## Application for Removal or Variation of a Condition following Grant of Planning Permission or Listed Building Consent

Change of use from office to residential with external alterations

23/00364

For the previously approved proposed elevations drawing 04 to be replaced by the revised proposed elevations drawing submitted with this application.

**Proposed Elevations**

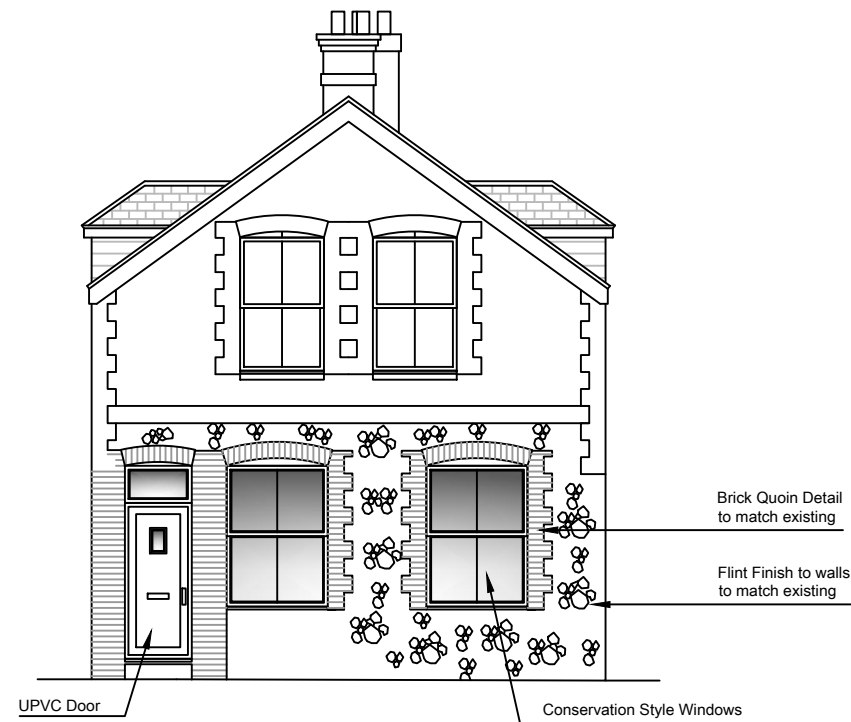
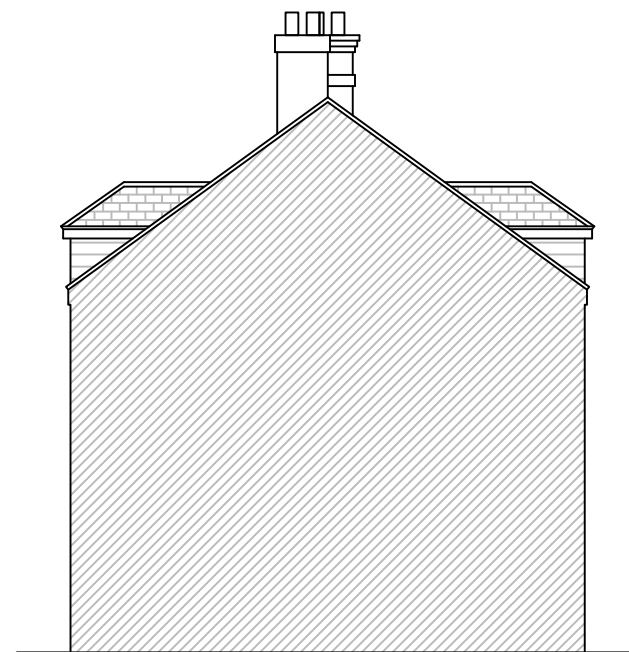
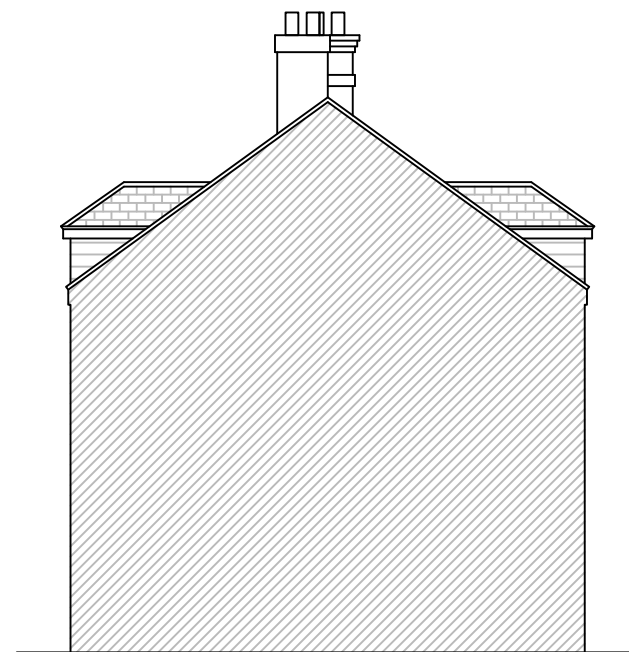
Proposed elevations drawing no 04 include conservation style windows to replace existing office windows, brick quoin details and part flint finish to the walls.

During building work and liaison with Building Control it was found that the lintels above proposed windows were structurally unsound and had to be replaced with deeper lintels. The installed windows are therefore shorter than approved plans and required a fibreboard infill panel above.

The front elevation right side window is wider than approved plans because the wall below the previous door and window was unsafe and had to be rebuilt.

The brick quoin details and part flint finish to external walls was not possible to match the existing and has been replaced by brickwork to match existing

To match the work that has been completed. Including fibreboard cladding panels above windows.
